**Growth, Environment  
& Transport**

**Re: Application for an Order Granting Development Consent for Stonestreet Green Solar – Relevant Representation Summary**

Following the Planning Inspectorate's Rule 8 letter dated 28 November 2024, the County Council wishes to submit its Relevant Representation summary as its submission was over 1,500 words.

Drawing Title  
INVERTER STATION  
ILLUSTRATIVE GENERAL ARRANGEMENT

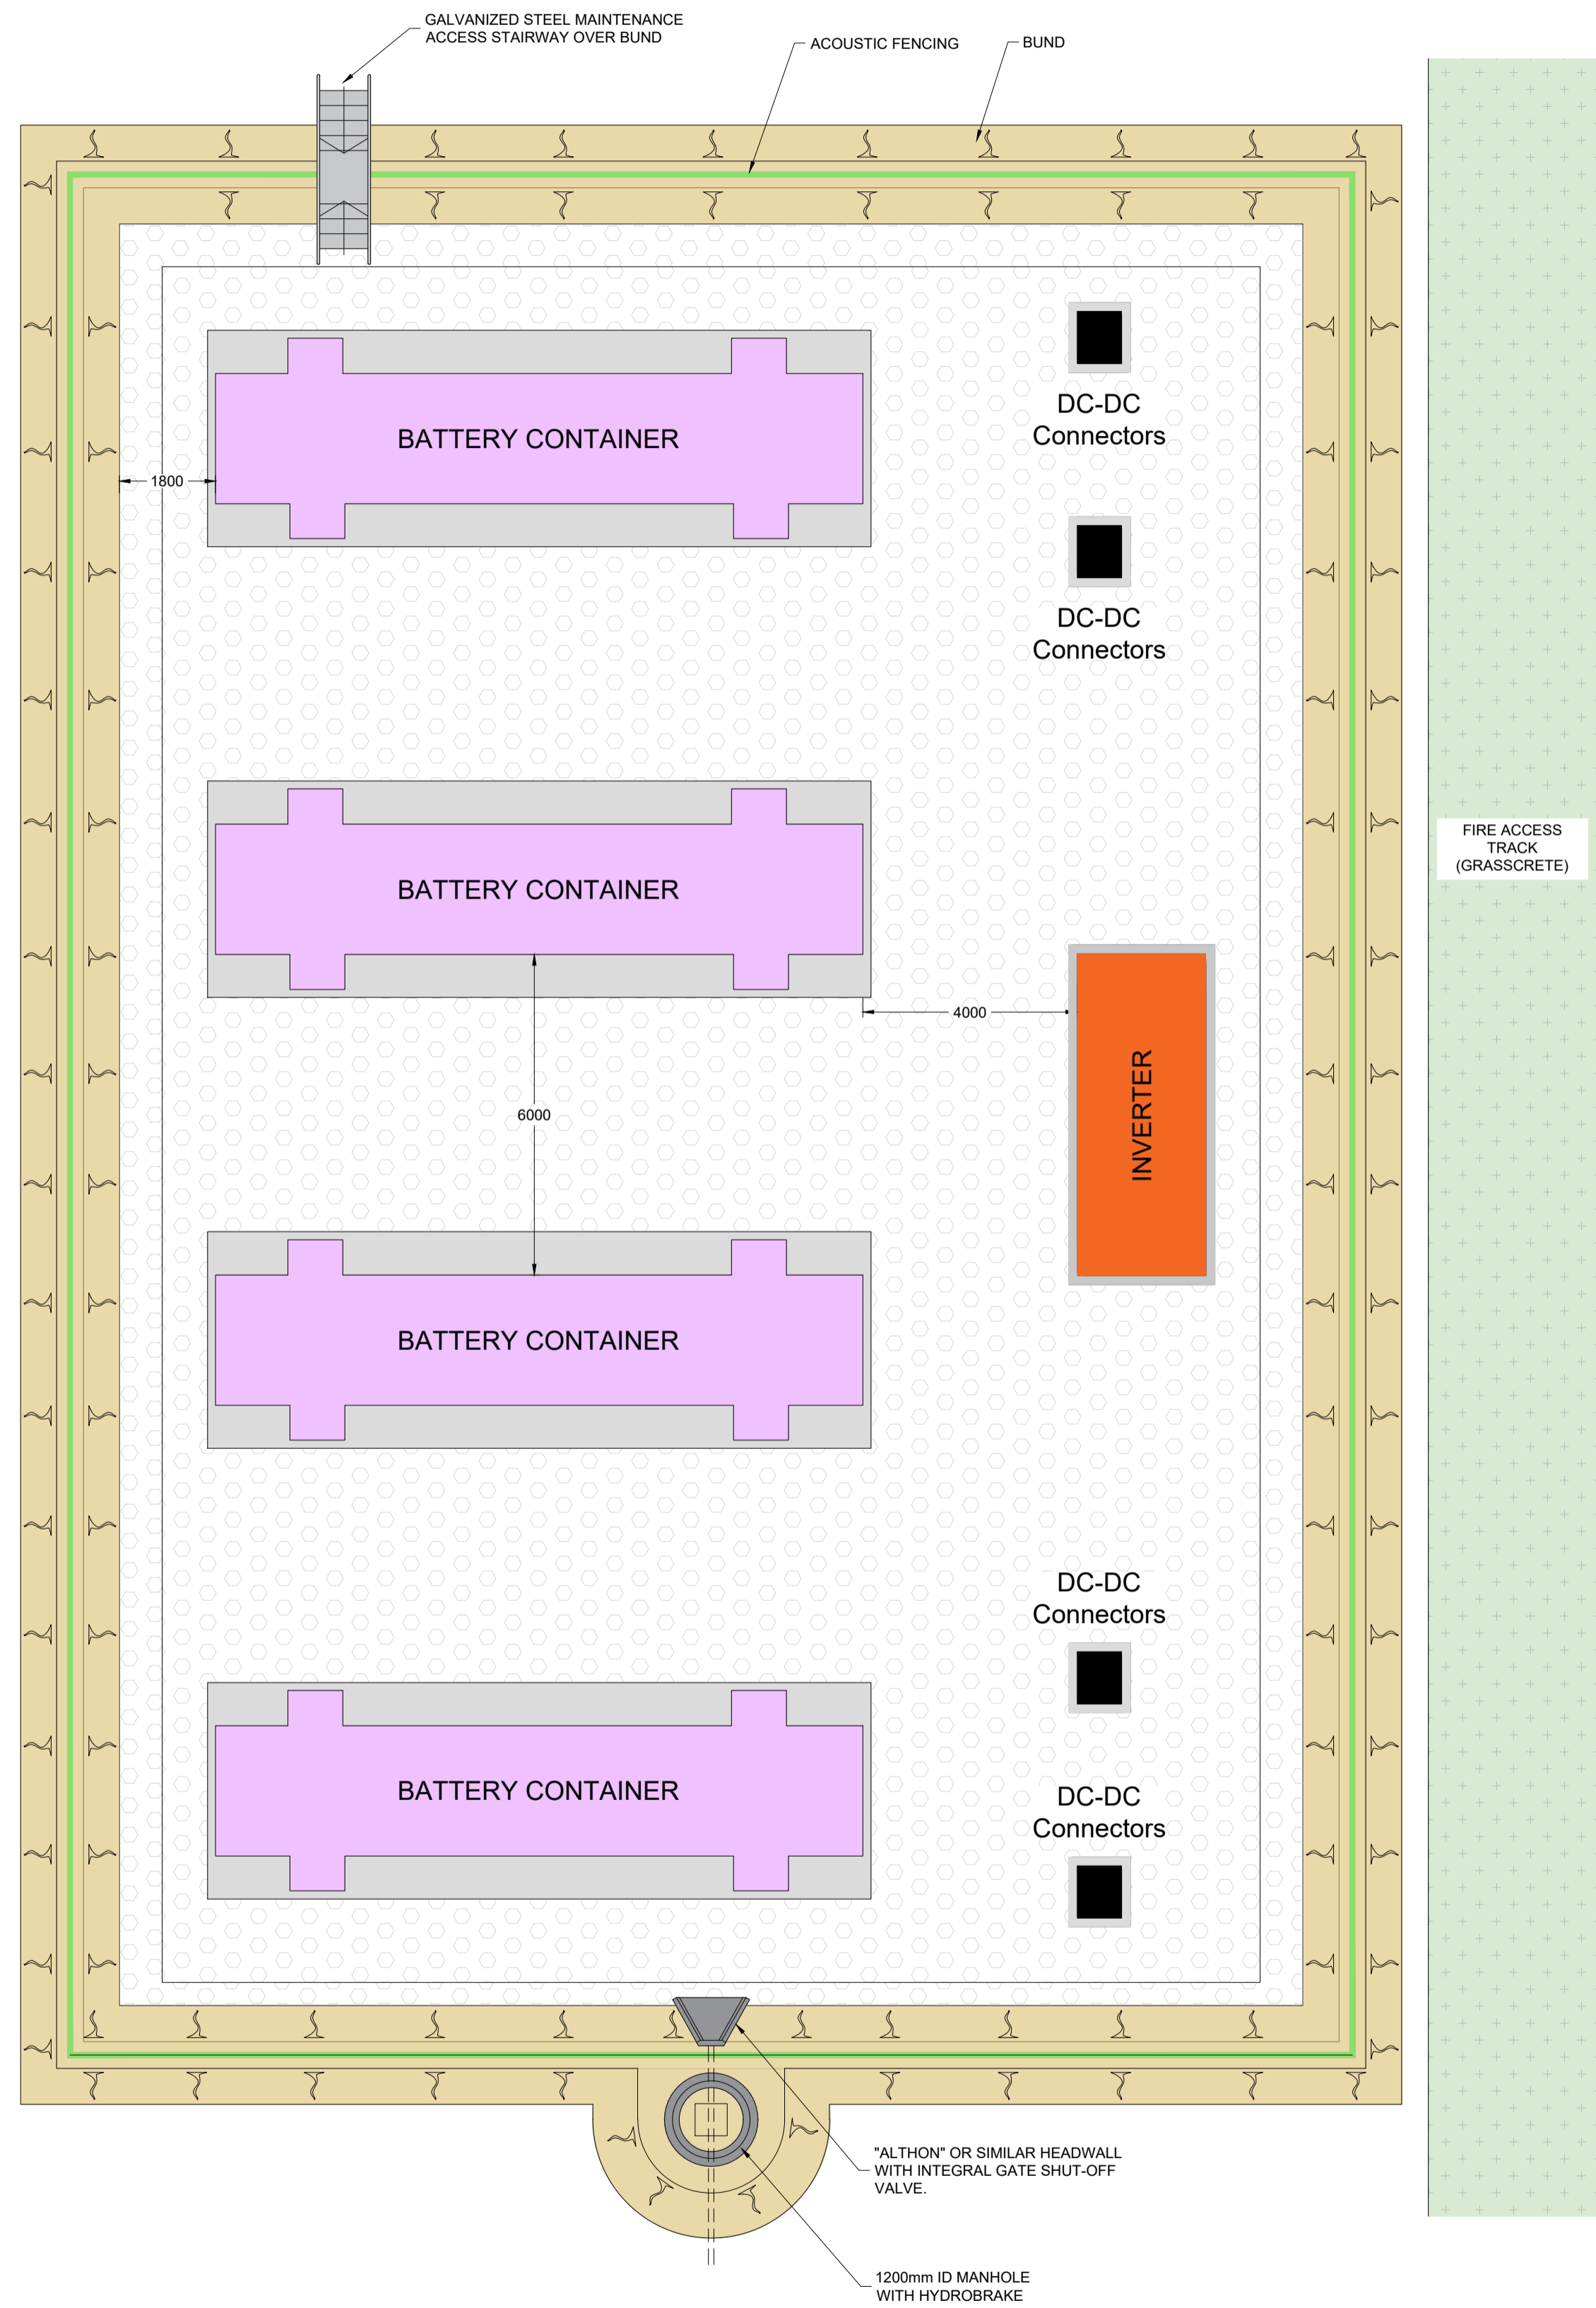
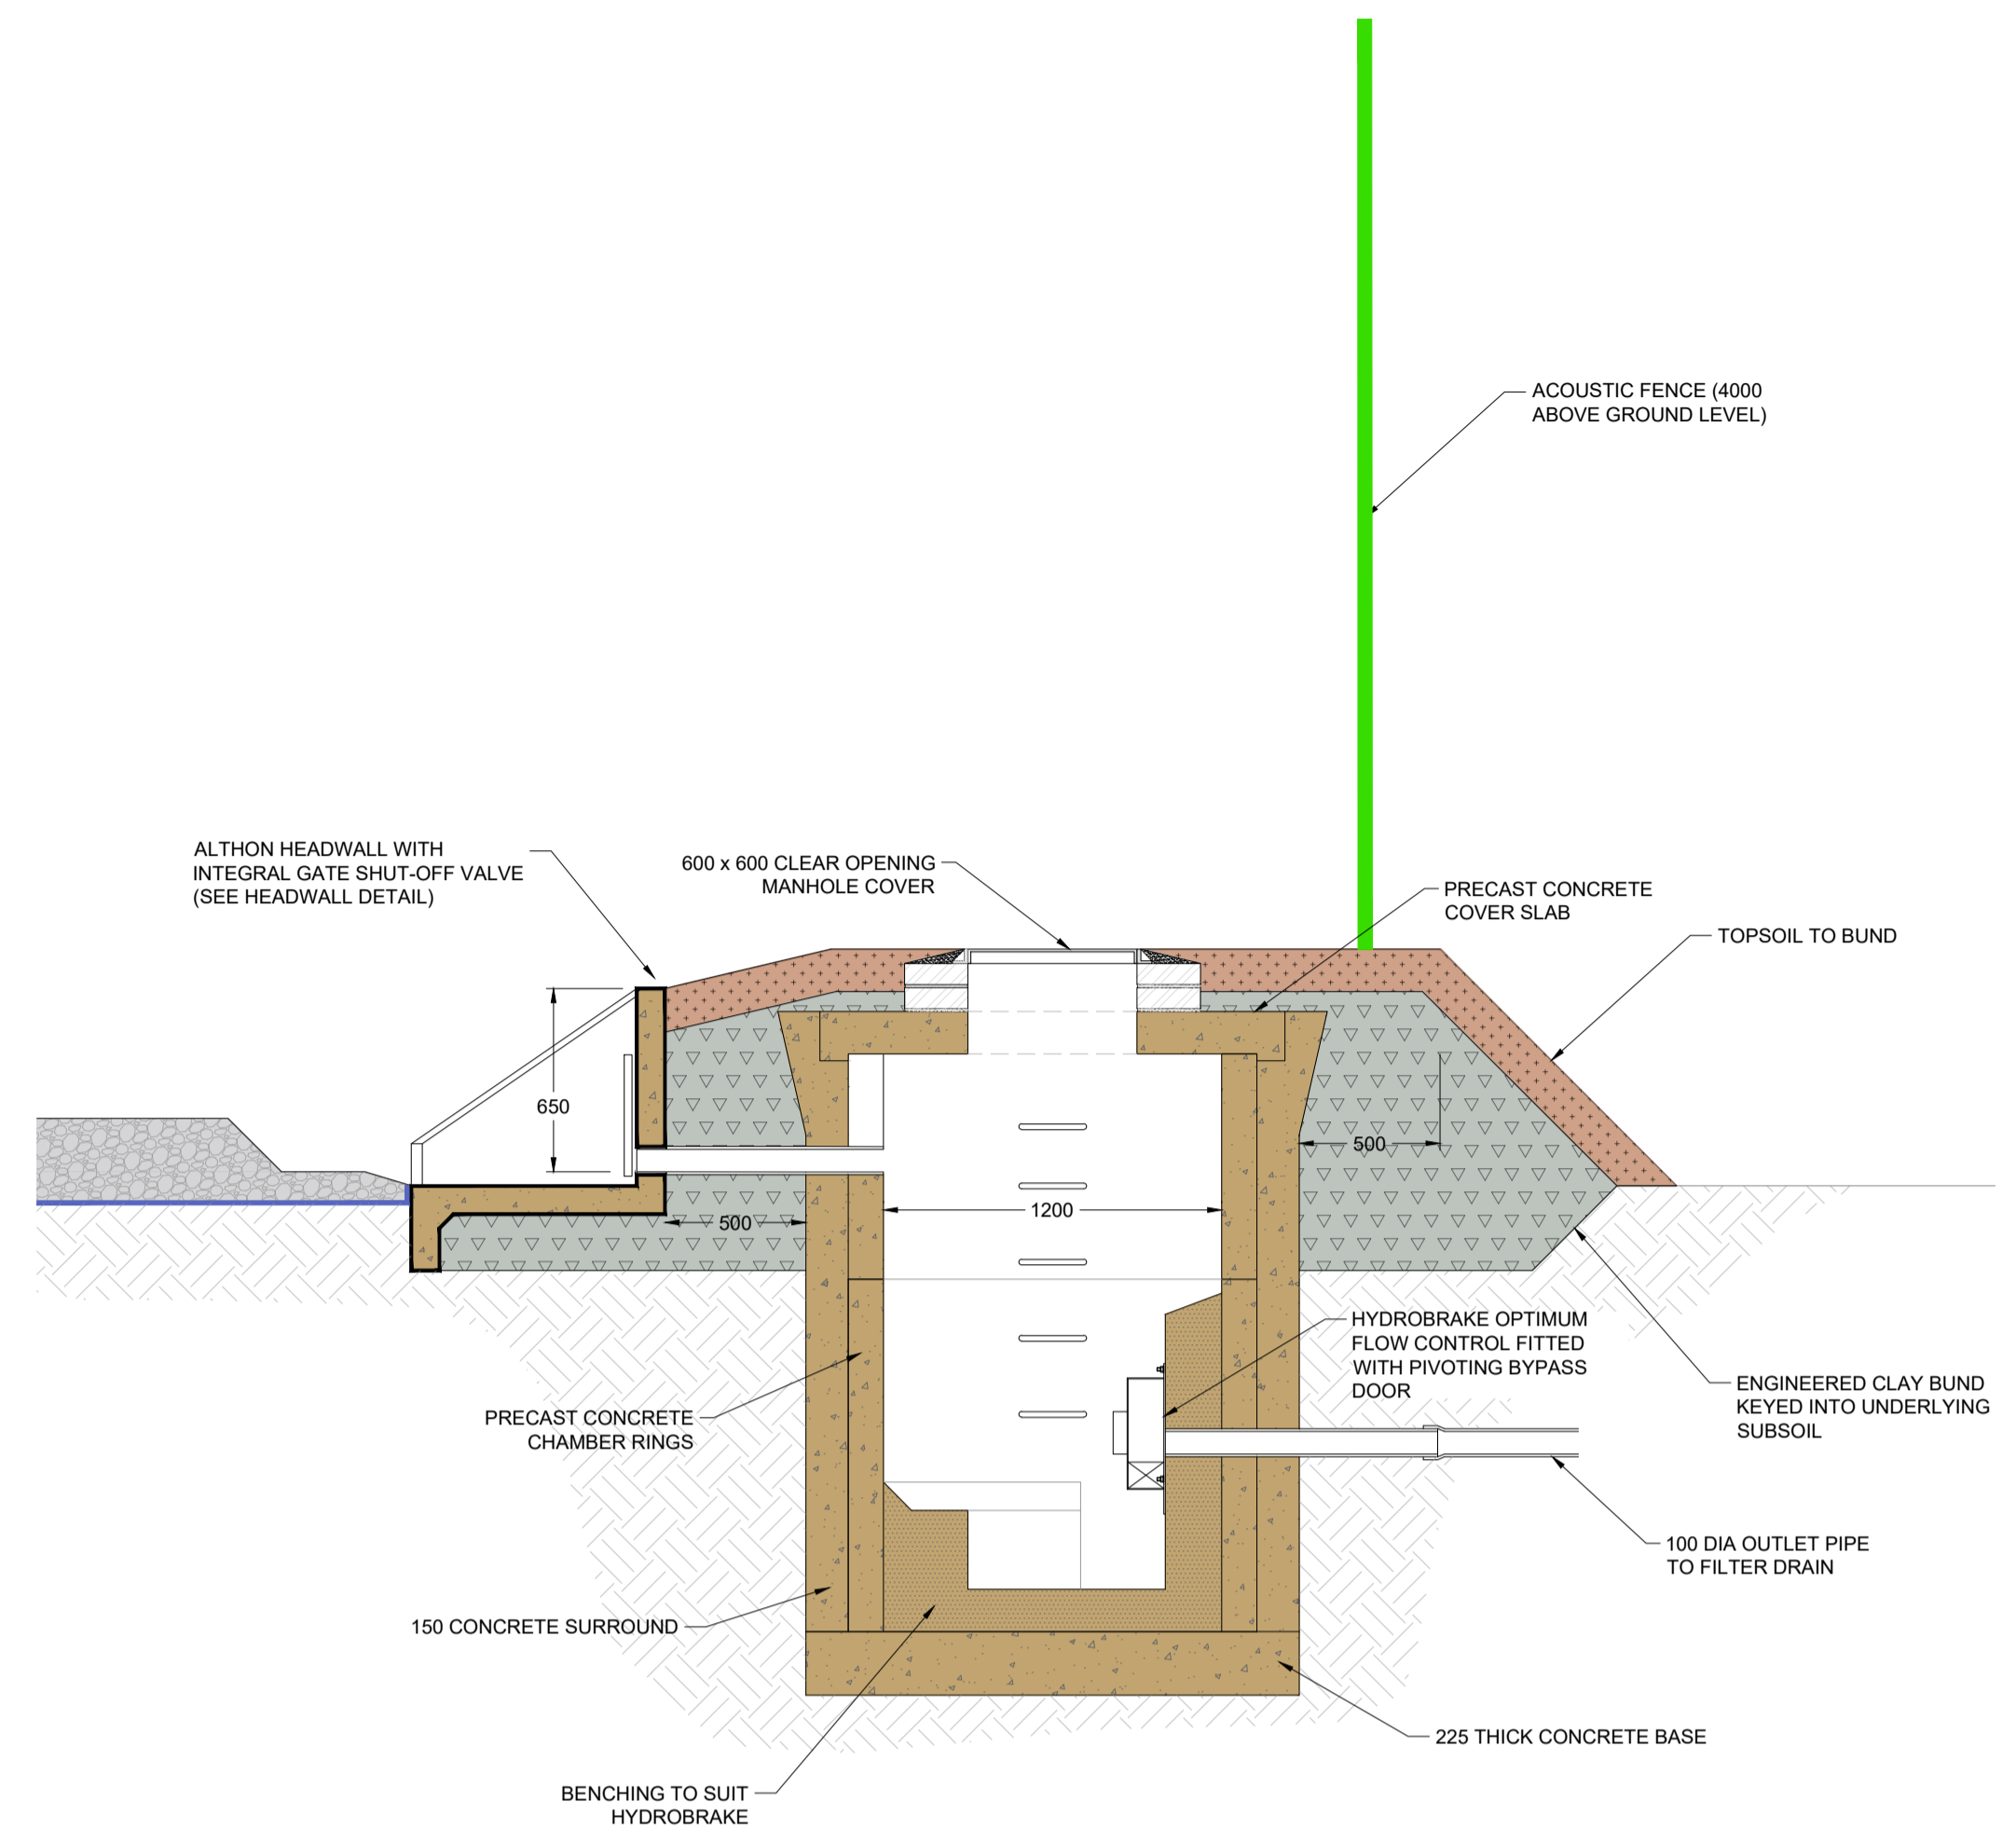
Whilst understanding the practicalities associated with low discharge rates, the County Council would suggest modifications to the design, such as the provision of additional attenuation with controls as part of the network, and not individually locating these at each inverter station position.
